October 5, 2022

**RE: Comment Letter for Proposed Demolition and Rebuild of 6950 SE Maker Street
Permit No. 2207-019**

GRADING, DRAINAGE AND UTILITY PLAN  
FOR  
**STRAND PROPERTY**  
6950 SE MAKER ST., CITY OF MERCER ISLAND KING COUNTY, WASHINGTON

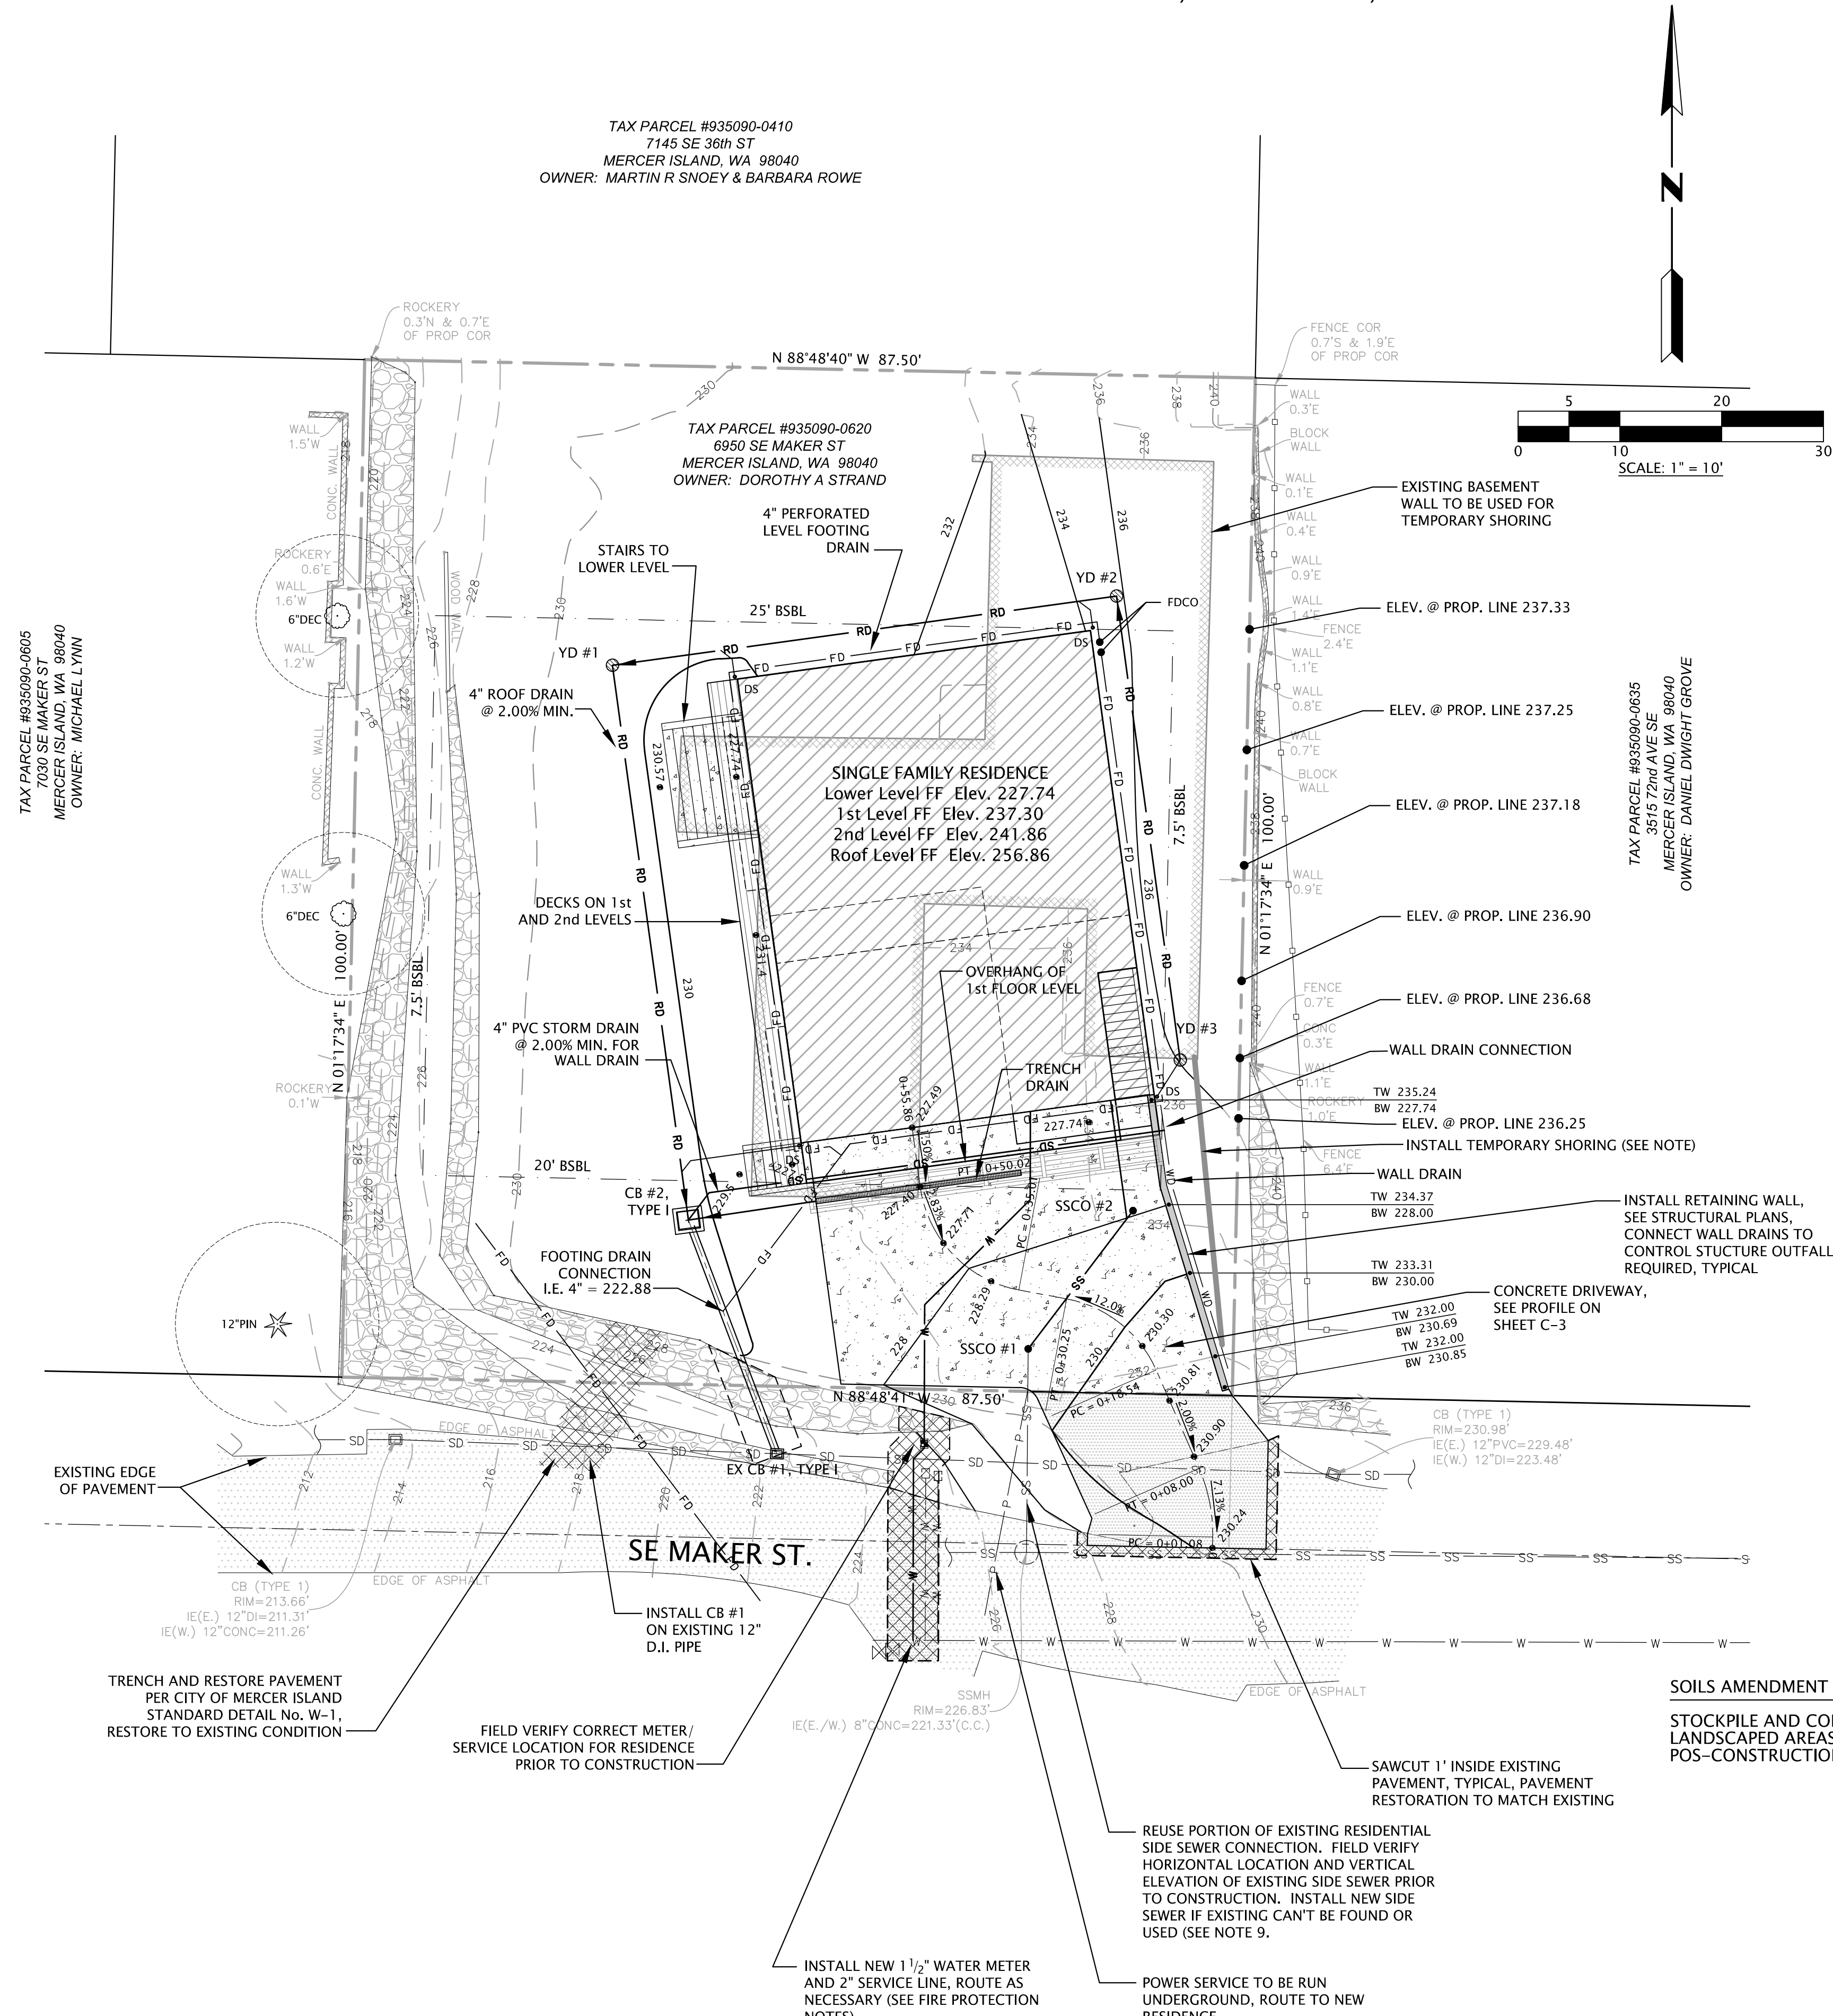
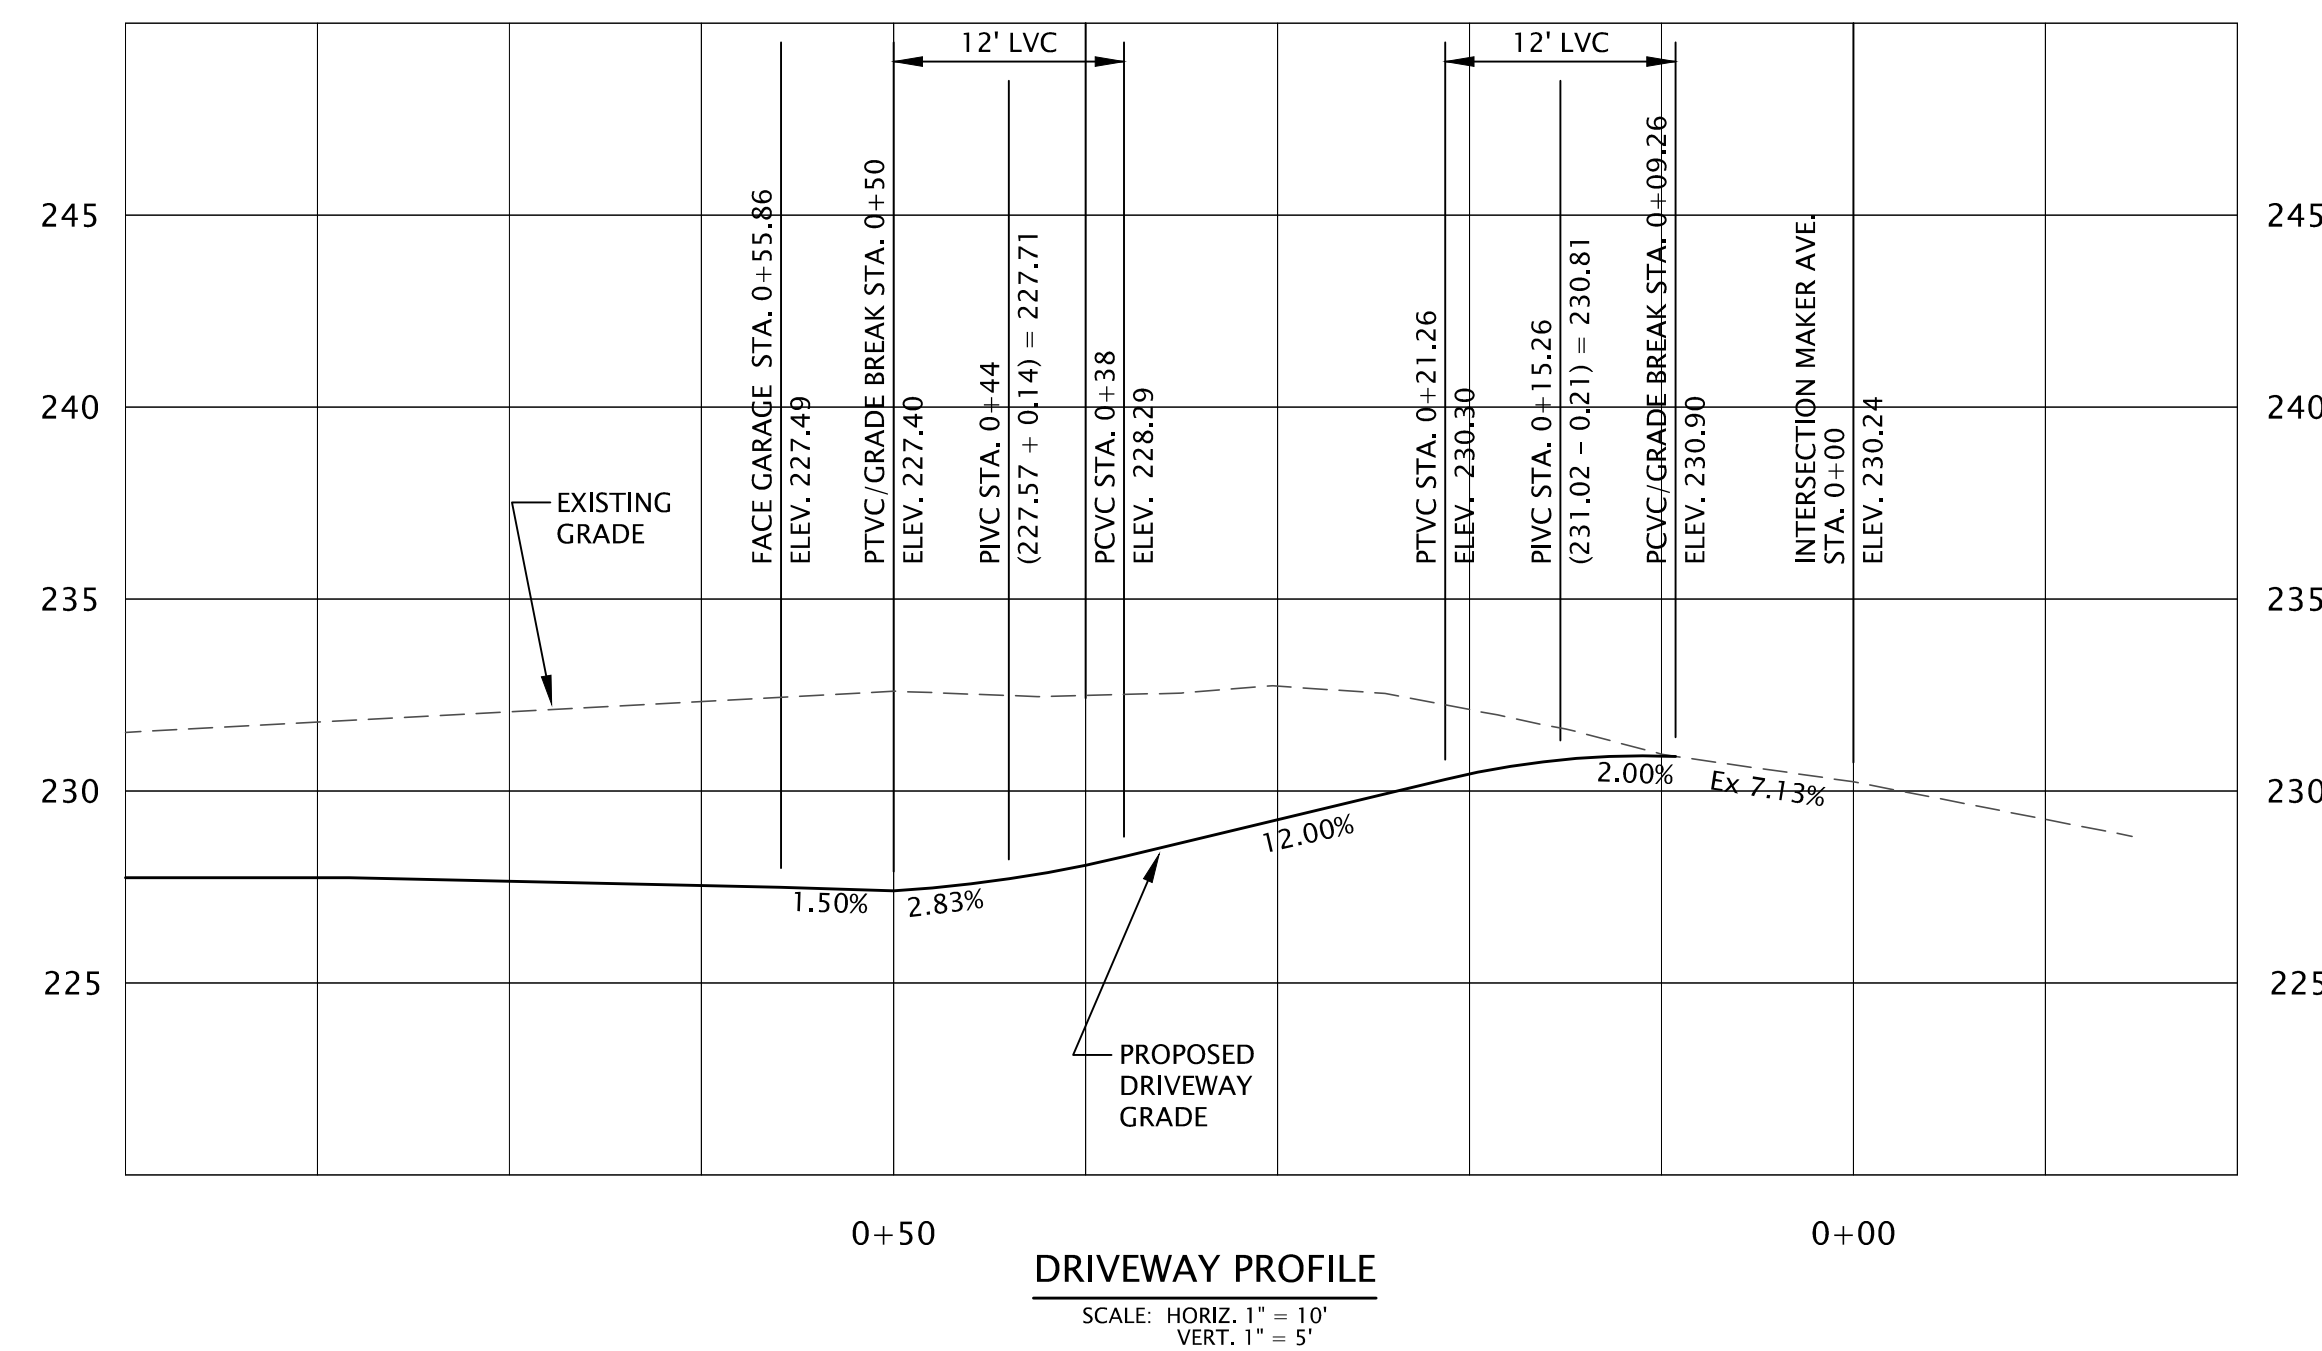
- No fill or substantial disturbance (including clearing, utility installation, or construction staging) within 20 feet of the existing western rockery;

- The proposed structure should be within the prescriptive minimum 25-foot buffer for shallow seated landslide areas, unless slope issues are mitigated and then the residence should be 20 feet from the western rockery,

The Geotech Study states that “detailed plans were not available at the time” of the Geotech Study.⁶ And, to date it is unclear from the permit plans whether additional analysis of the detailed project plans took place. For instance, parts of the proposed structure are closer than the 25 foot (and even the 20 foot) recommended buffers, and construction and staging will likely occur within the west side of the project. It is also unclear whether an adequate slope stabilization system will be implemented.
